Will be reviewed with the resubmittal.  
 Only the coversheet of the construction drawing was revised. The rest of the sheets to include the GEC is the same as the first submittal.

# EL PASO COUNTY PLANNING AND COMMUNITY DEVELOPMENT DEPARTMENT

## GRADING AND EROSION CONTROL PLAN CHECKLIST

S:\architect\rolling hills\dwg\plan sheets\improvement plans\01_RH1.dwg, 11/15/2019 7:45:22 AM

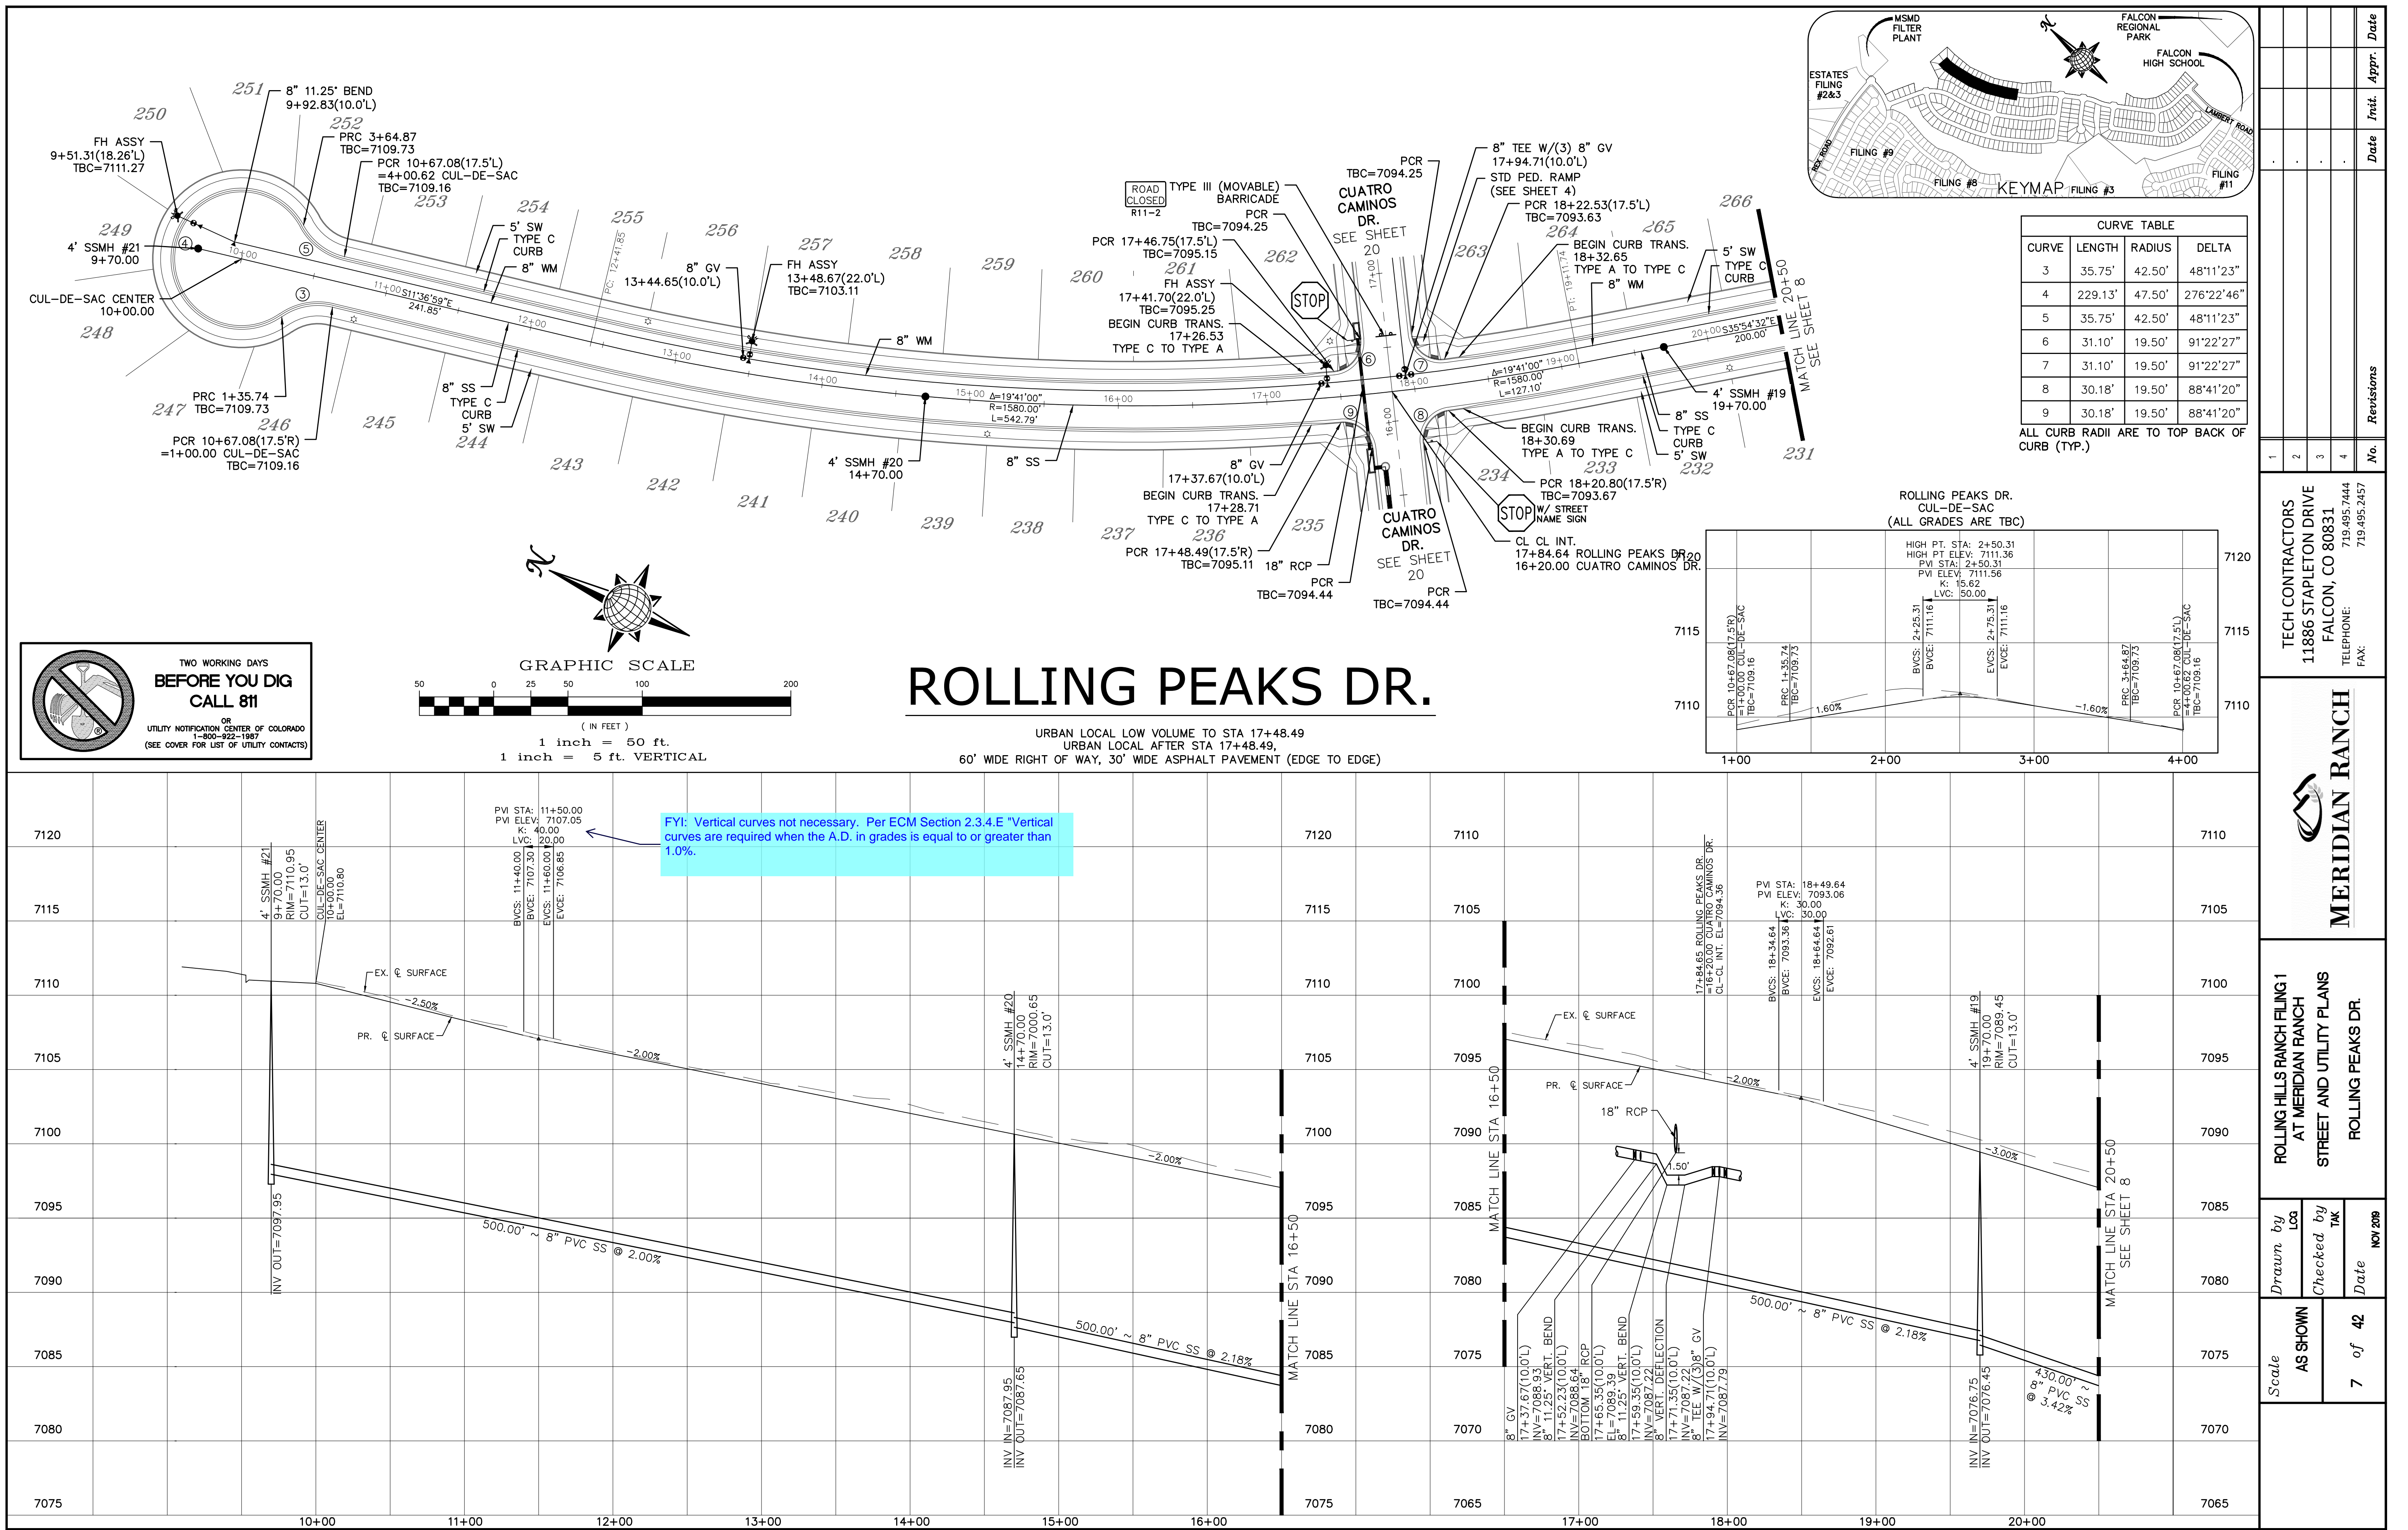
statement on the plans does not match

The owner's statement identifies compliance with all of the requirements specified in these plans. The grading and erosion plans are part of the plan set. Separate statement is unnecessary neither is rewording it necessary. No change to the plans

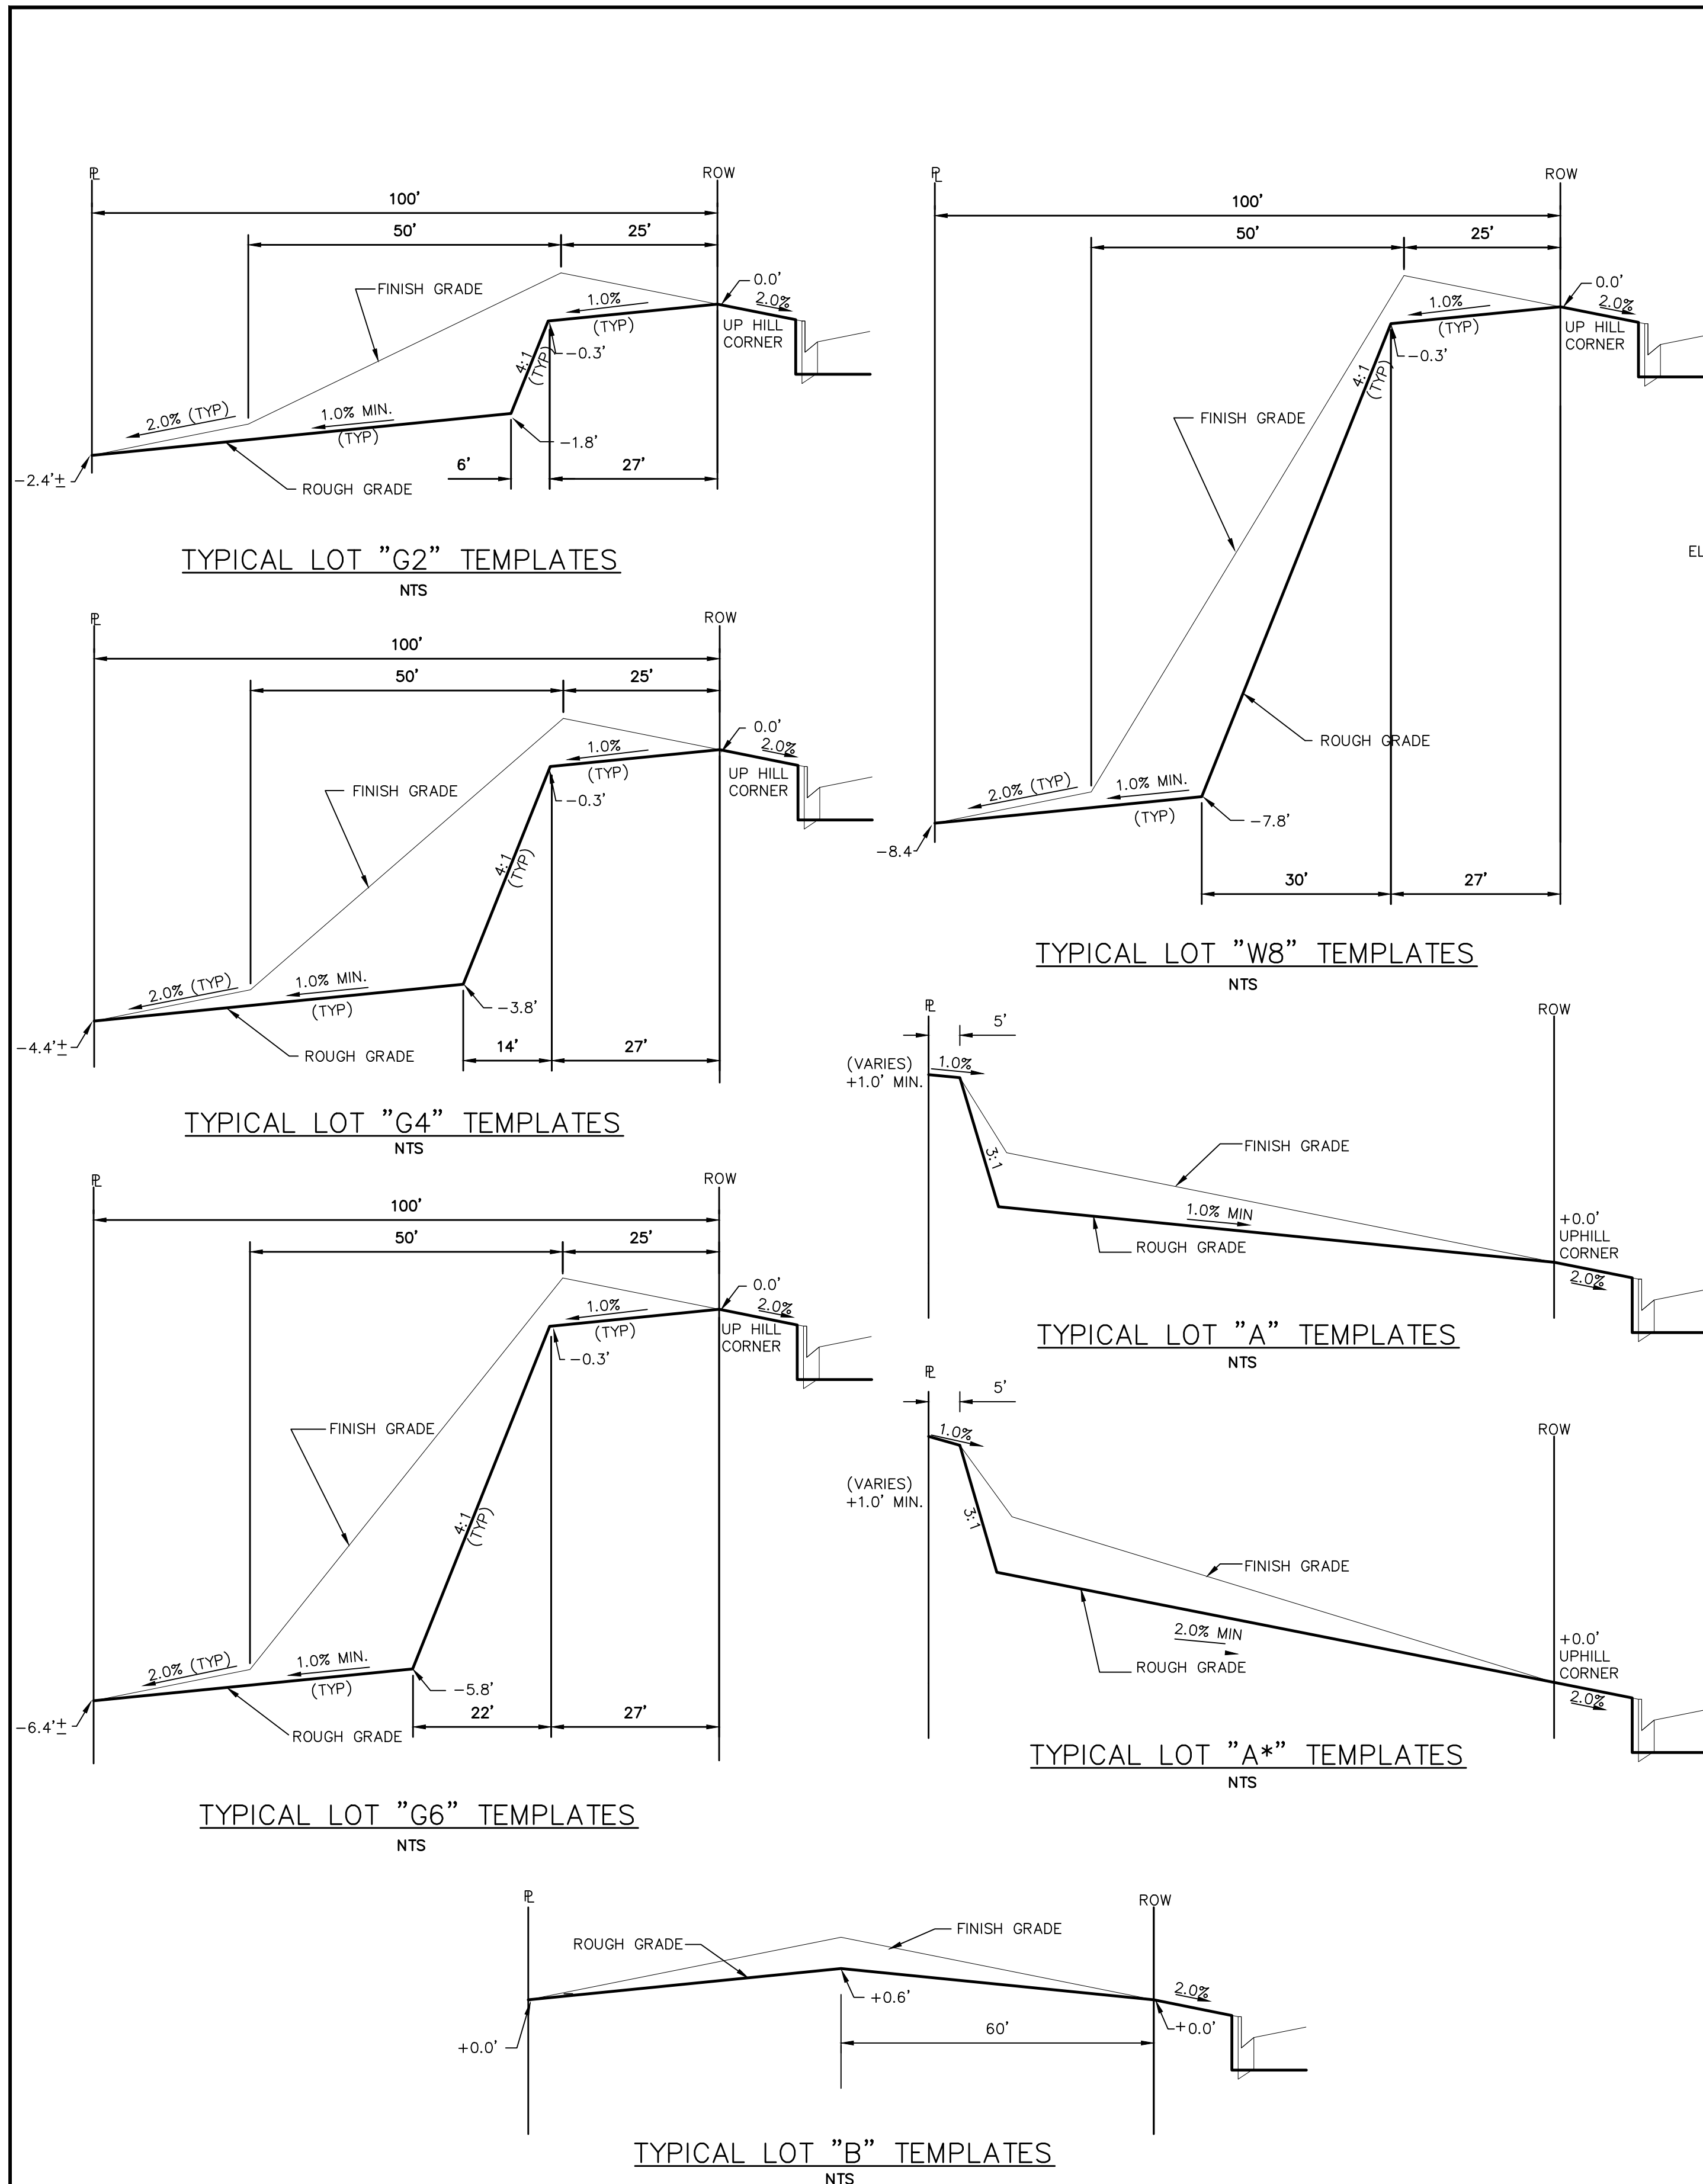
v	All proposed temporary construction control measures, structural and non-structural. Temporary construction control measures shall be identified by phase of implementation to include "initial," "interim," and "final" or shown on separate phased maps identifying each phase.	X	✗
w	Vehicle tracking provided at all construction entrances and exits. Erosion control signage provided at access points not to be used for vehicle access.	X	✓
x	Temporary sediment ponds provided for disturbed drainage areas greater than 1 acre.	X	✓
y	Dewatering operations to include locations of diversion, pump and discharge(s) as anticipated at time of design.	n/a	✓
z	All proposed temporary construction control measure details. Custom or other jurisdiction's details used must meet or exceed EPC standards.	X	✓

Corrected, added schedule as shown on RHR Standalone grading. (Sh 32)
